From: Laura Gibbons <Laura.Gibbons@arun.gov.uk>
Sent: 03 November 2020 12:08
To: Planning.Responses <Planning.Responses@arun.gov.uk>
Cc: Simon Davis <Simon.Davis@arun.gov.uk>
Subject: Y/72/20/RES

Engineers Comments Regarding Surface Water Drainage

Reserved Matters Comments

PERMEABLE PAVING CONSTRUCTION DETAILS

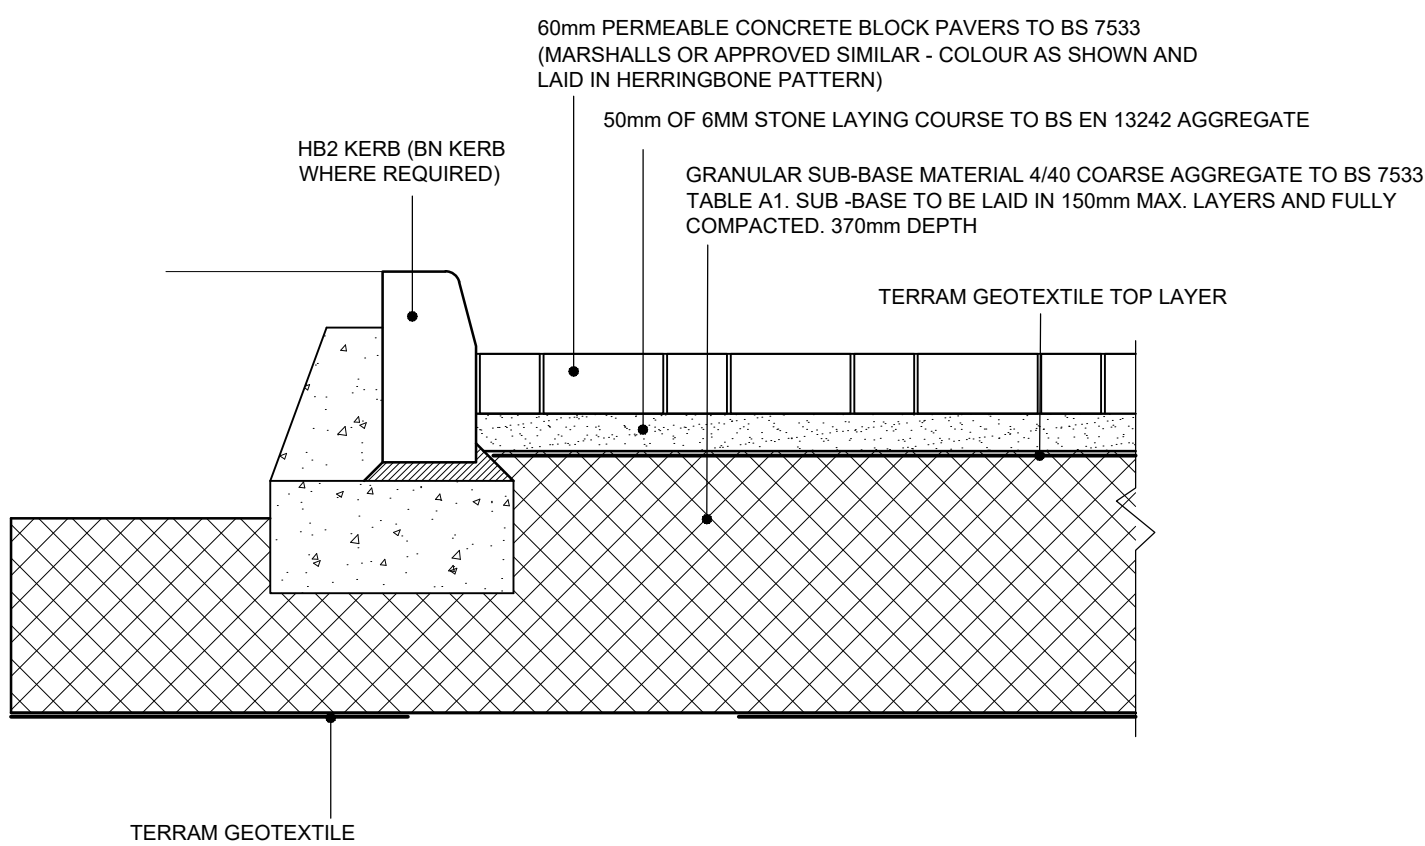
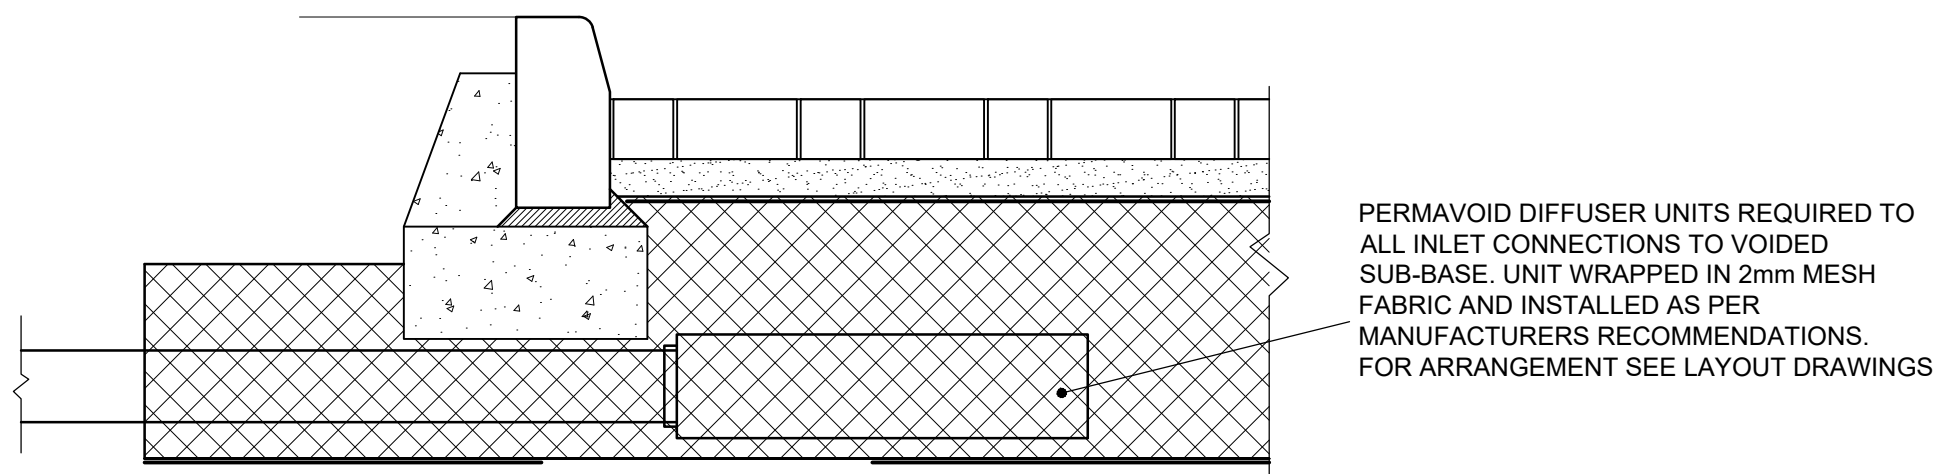
- 1. The checklist has been corrupted as part of the scanning process. However, it is understood from previous dialogue and the adjacent site that all infiltration devices are kept to a maximum of 600mm depth. Yet many areas of permeable paving have a sub-base proposed beyond 600mm depth. Please review or provide evidence that all features are located above peak recorded groundwater level, i.e. put groundwater levels on the drainage plan. The basin has been removed from proposals and replaced with a large blanket crate area. The invert level of the proposed crates is above the peak recorded groundwater level at the two*

- e. All permeable paving areas have been modelled with a sub-base depth of 600mm. Yet on plan different road types are specified that have a sub-base depth less than this. Please ensure consistency between drawings and calculations.

INFILTRATION BASIN WITH INFILTRATION BLANKET BENEATH

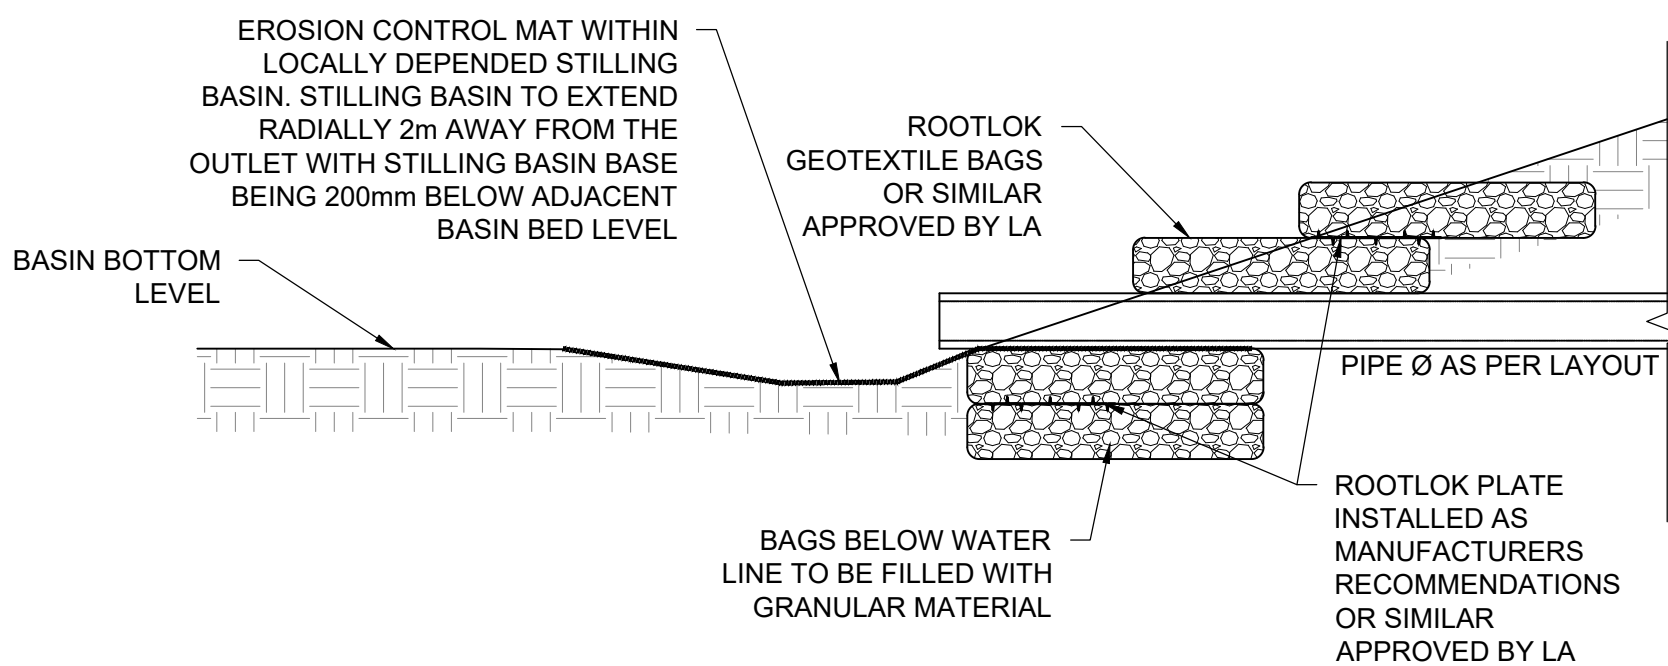
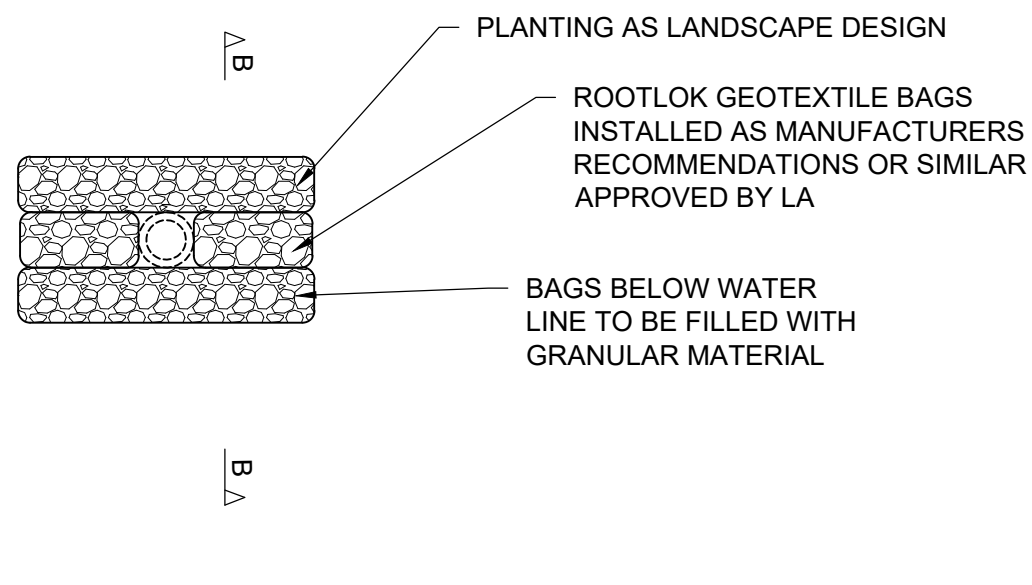
1. *Successful resolution of the above reserved matters points.* Awaited.
2. *Please provide two perpendicular site specific cross sections of the proposed infiltration basin. These should show invert level, maximum water level, bank level, construction including connection between sub-base and basin.* Not required- construction drawing of tank provided. Please state minimum cover depths on drawings. Please include bed and surround material on drawings.
3. *Please provide construction detail drawings of pipe bed and surround.* Okay.
4. *Please clearly indicate on plans where the different permeable paving types shown on the construction drawing are proposed.* See comment 5e above.
5. *The maintenance manual will be reviewed once the design has been agreed.* Will be reviewed once design is more finalised.
6. *Further comments are likely once details are further reviewed.*
